City of Albuquerque

September 18, 2003

Re: Arno Subdivision Grading and Drainage Plan
Engineer's Stamp dated 8-11-03 (J14/D146)

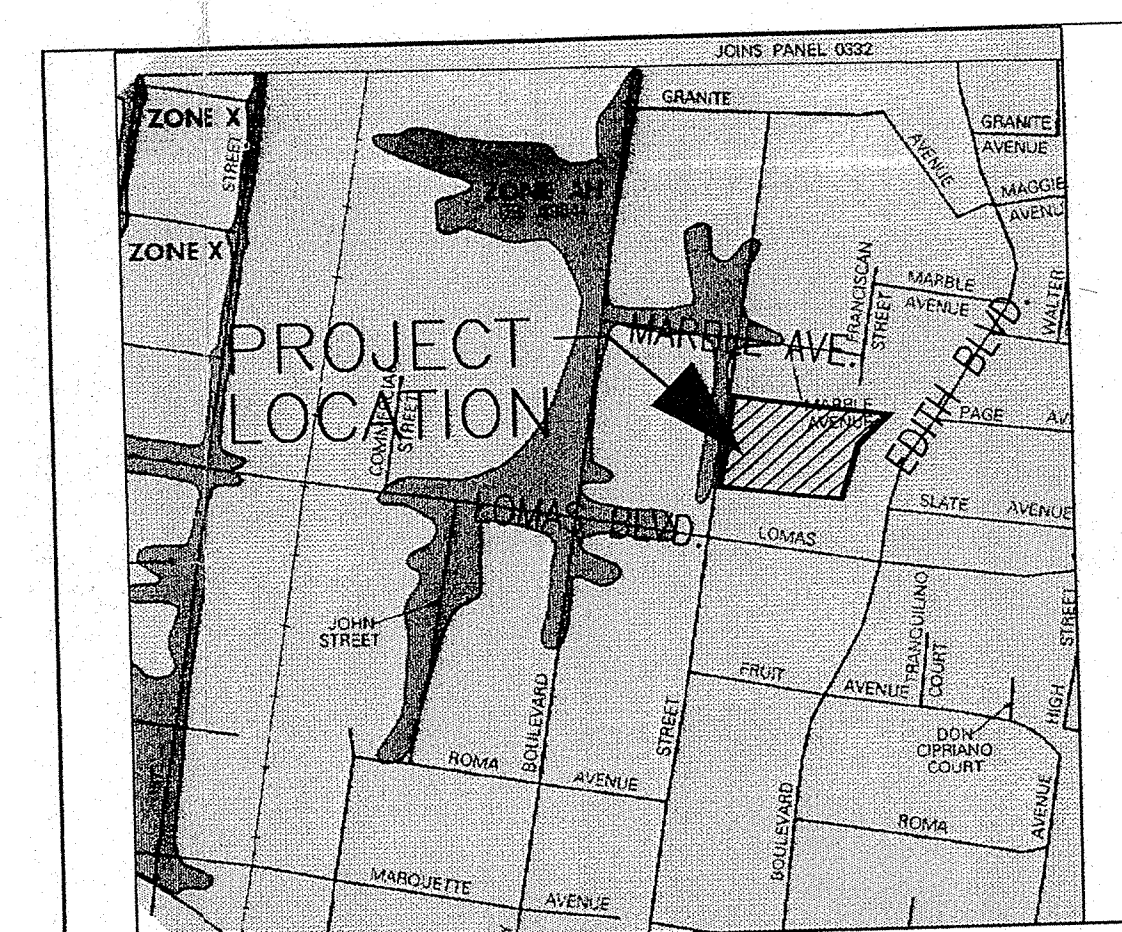
- The DPM states that the normal depth can be no higher than the top of curb and the depth plus velocity head ($d+v^2/2g$) cannot exceed 0.2 feet above the top of curb. There will need to be a transition to standard curb somewhere near Arno.
- The retaining wall must be made of masonry or concrete. Railroad tie retaining walls don't work to divert water and the City has had a fair number of complaints from homeowners whose walls have failed. Who will maintain the sediment pond and swales?
- Please provide the benchmark on the plan.

1. Please see attached calculations, the plan is to move the sidewalk behind the mountable curb for approximately 95 feet east of Arno Street in-order to maintain the velocity head within a hardscape structure.
2. As per our discussions the details for the railroad tie retaining wall show concrete placed in the hole for the railroad ties, also the requirement of depth of burial equal to height should sustain the wall for quite some time. The sediment pond and swales will be maintained by the private property owners, such maintenance language will also be included in the plat.
3. A bench mark is now included on the plan.
